## WEST SUSSEX COUNTY COUNCIL CONSULTATION

| <b>FROM:</b>                    | WSCC - Highways Authority                                                                                                                                                                                                                                                                            |
| <b>LOCATION:</b>                | Land adjacent to Sefter School House<br>Sefter Road<br>Bognor Regis<br>PO21 3EE                                                                                                                                                                                                                      |
| <b>SUBJECT:</b>                 | P/116/19/OUT<br><br>Outline application with all matters reserved for the erection of 4 No. semi-detached 3-bedroom houses & 2 No. detached 4-bedroom houses with associated access, parking & gardens. This application is a Departure from the Development Plan.<br><br>More information received. |

Swept Path Analysis – 11.2 Metre Refuse Collection Vehicle

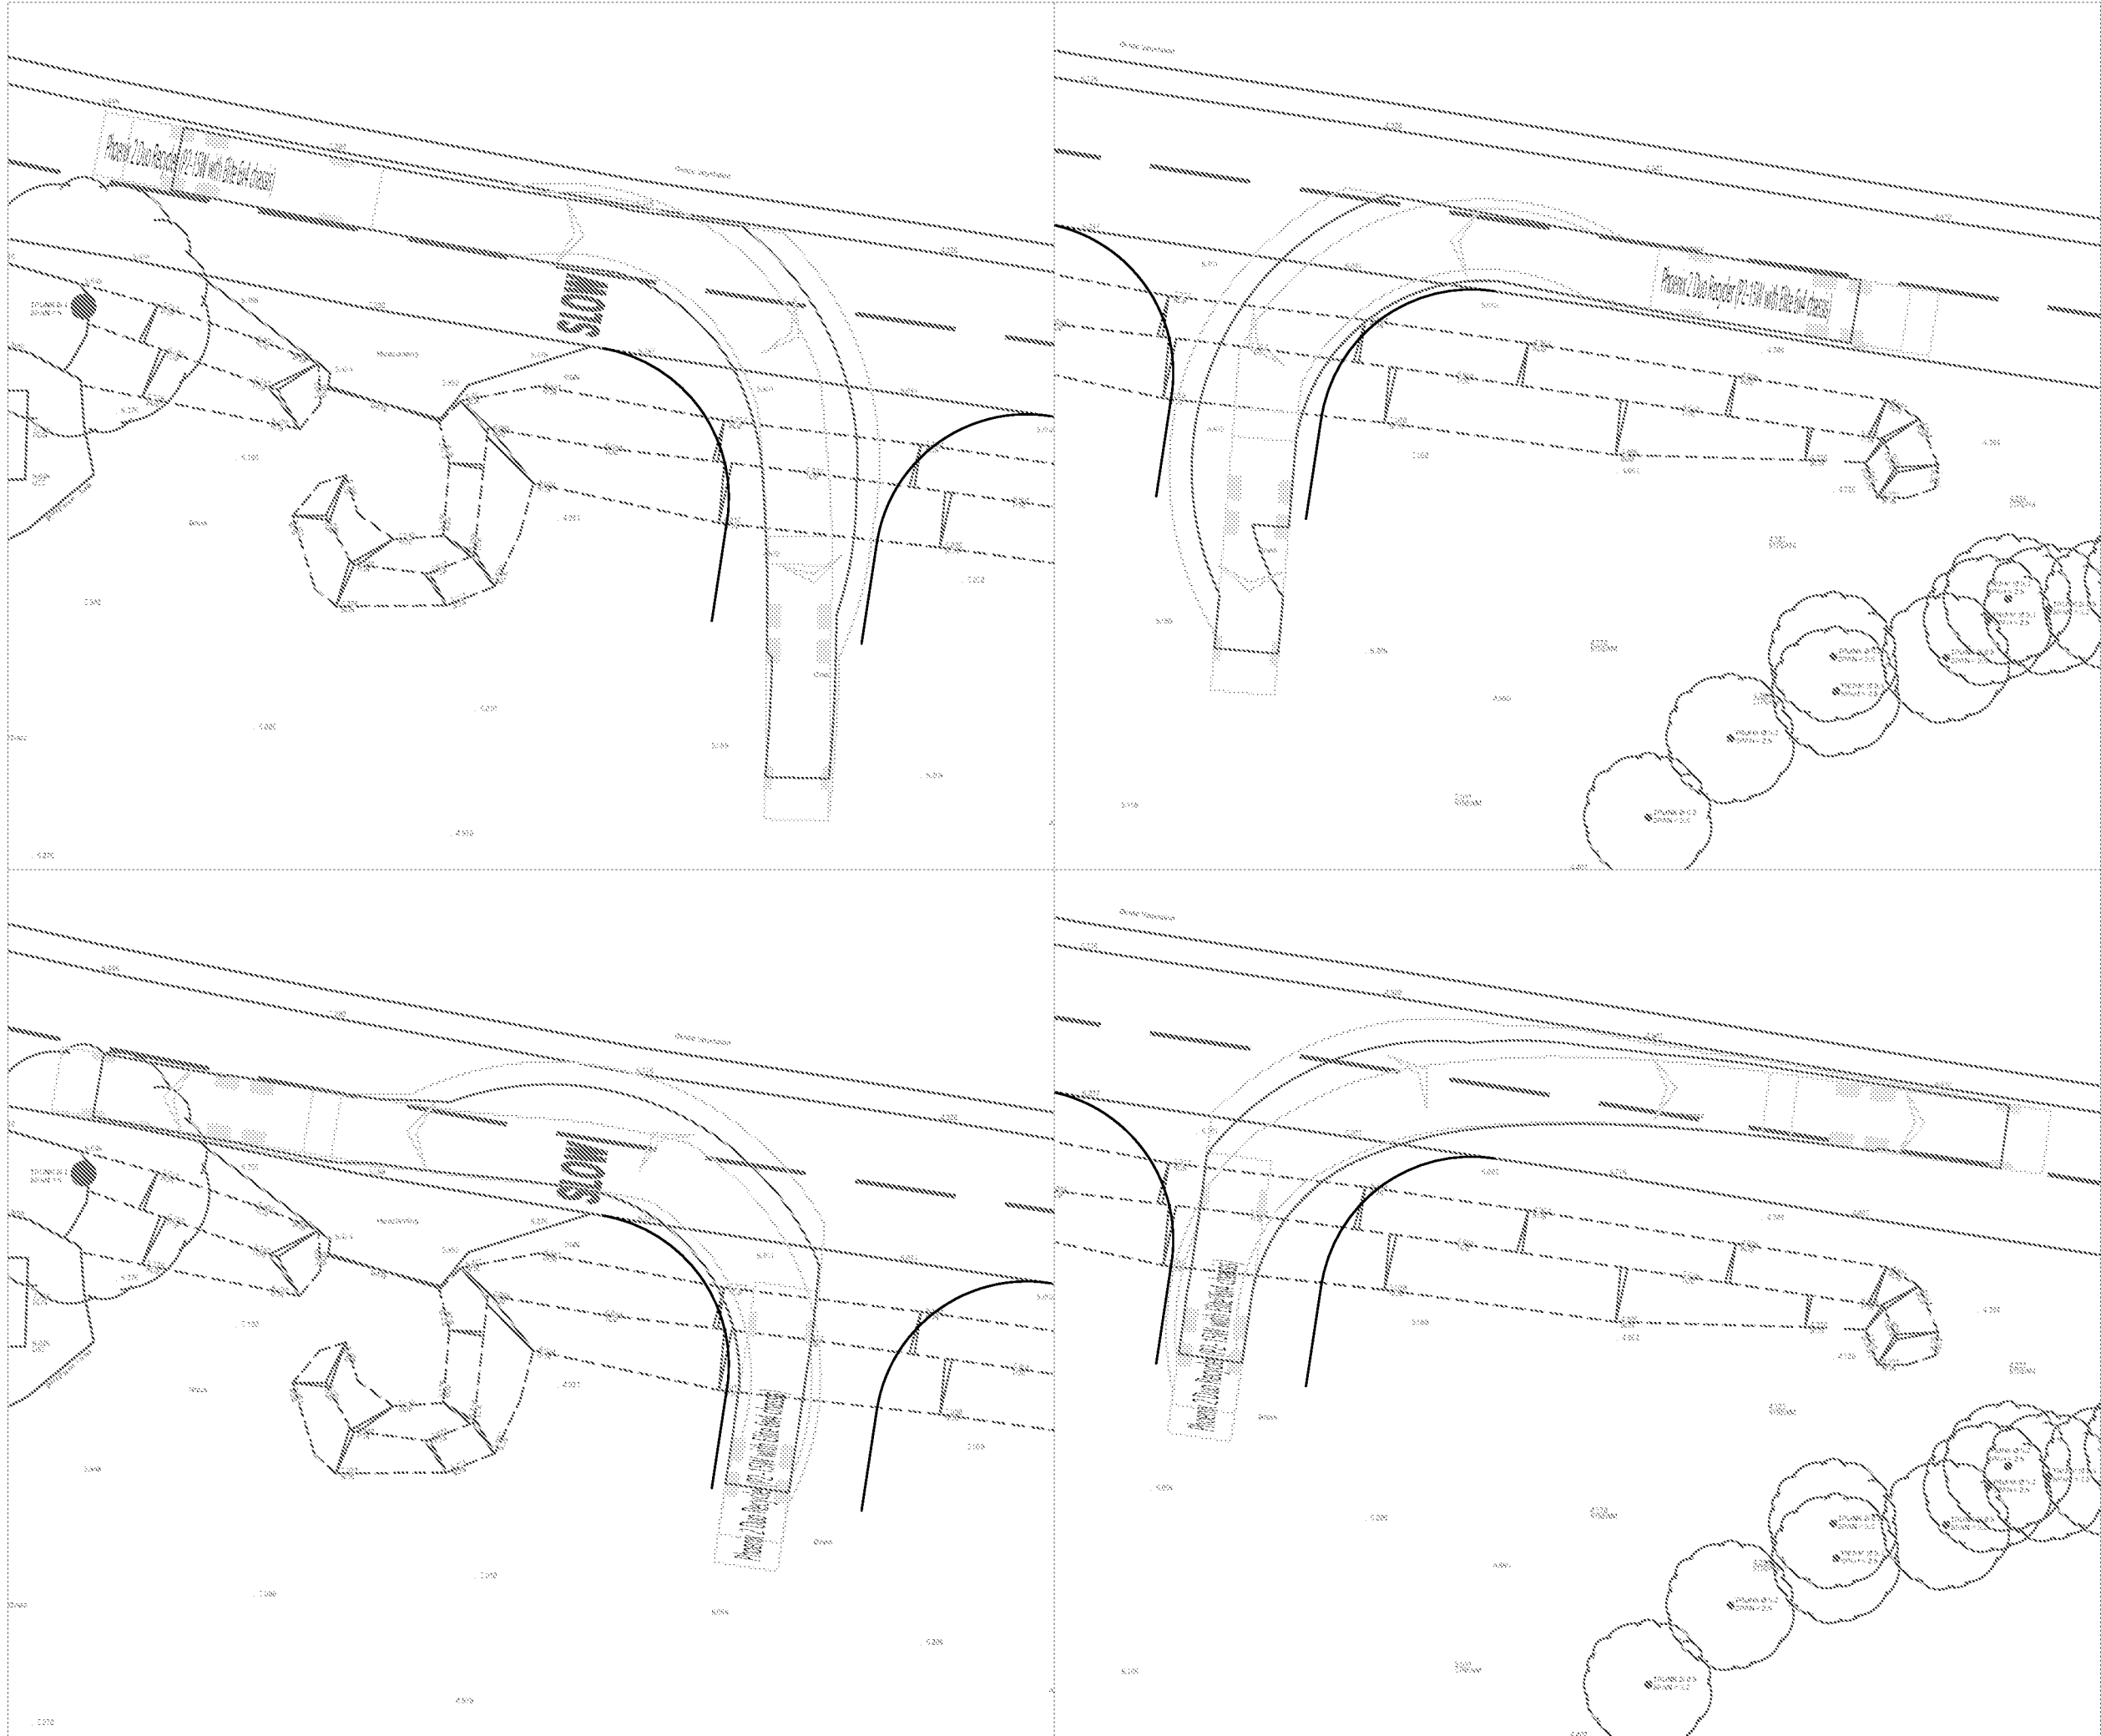
The applicant has supplied kerb radii details showing 6 metres and an access width of 6 metres. Tracking has been supplied showing a mixture of vehicles including a worse case scenario of a refuse truck. The LHA are satisfied with these details.
